**Your Ref:** OWPC18594  
**Our Ref:** CM/10/18/OUT 03-04-2018  
**Please ask for:**  
Mr J Baeza

Application for Outline planning permission with some matters reserved for redevelopment of the site with 1 No. 4-bed detached bungalow, 1 No. 3-bed detached chalet bungalows & 2 No. 3-bed semi-detached bungalows & associated works.

Mistletoe Farm Horsemere Green Lane Climping

Thank you for your internet representation made on 4th June 2018 which has been recorded as '**an objection**' with the comments as follows:

1071/DPA05

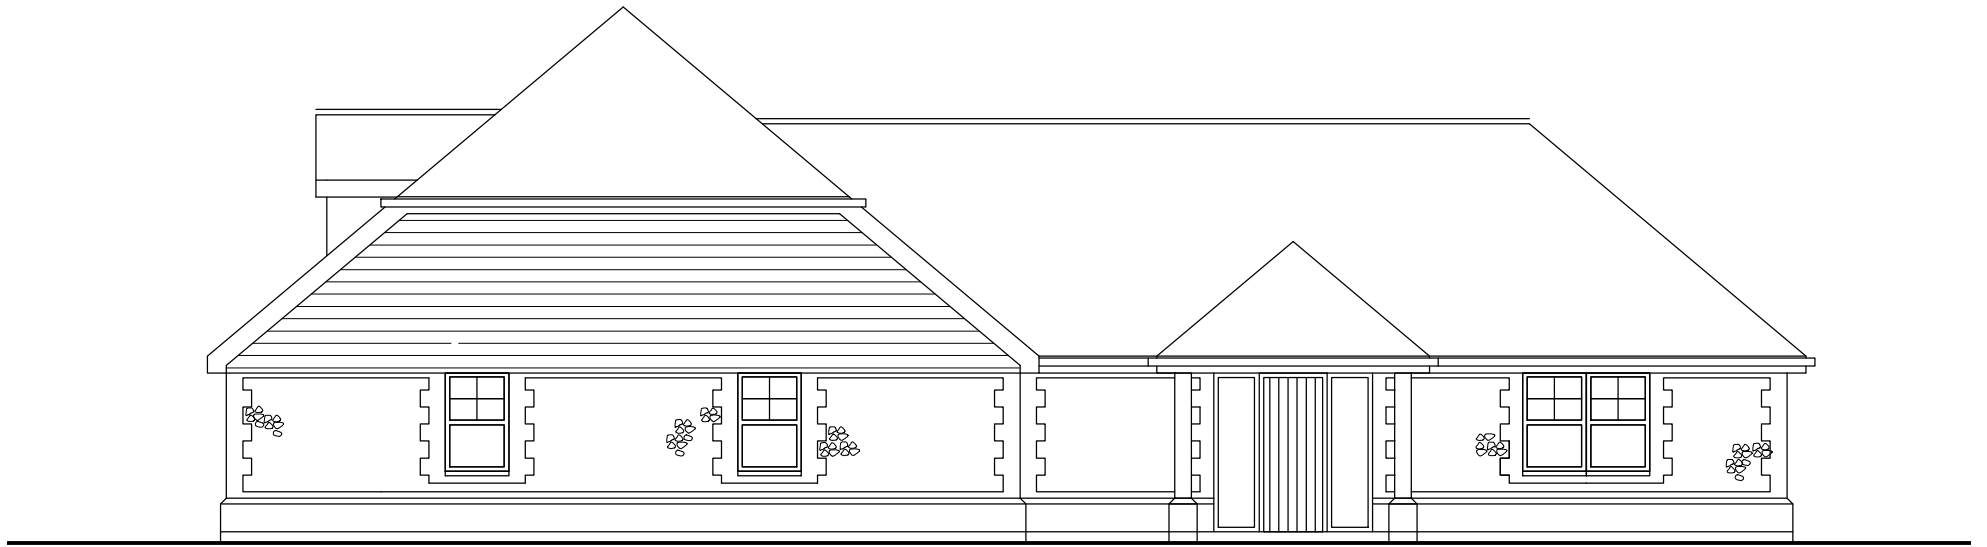
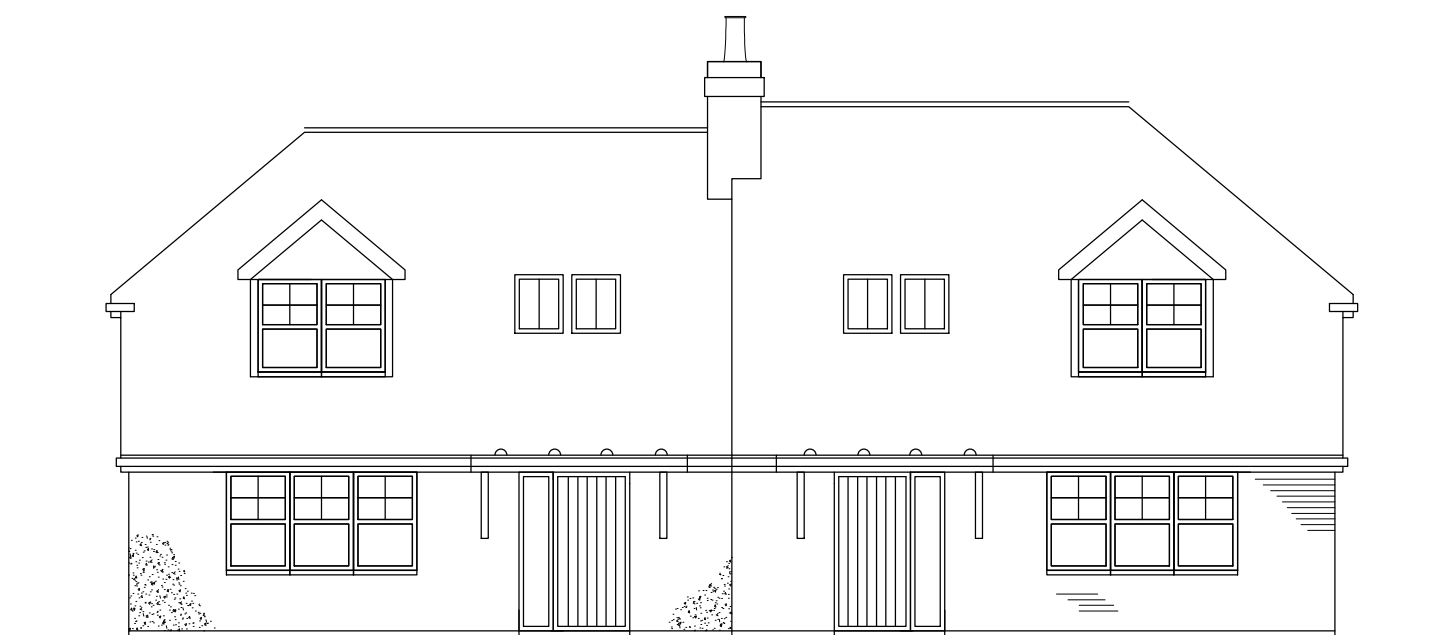
- 1) Plots 2 & 3 still contain 2 storey properties which will overlook the bungalows in Wooldridge Walk and Mant Close.*
- 2) My attention has been drawn to the position of the Southern Water sewage route which crosses Mant Close and Wooldridge Walk and enters Mistletoe Farm at its southern end. It then goes northwards the whole length of Mistletoe Farm towards Horsemere Green Lane. I believe that there should be no construction allowed within 3 metres of drains or sewers but according to the amended plan Plot 3 and Plot 4 and the garage in between are all too close to the sewer.*
- 3) It is undeniable that birds and other wildlife will be severely adversely affected by the removal of trees and hedges to accommodate this development.*
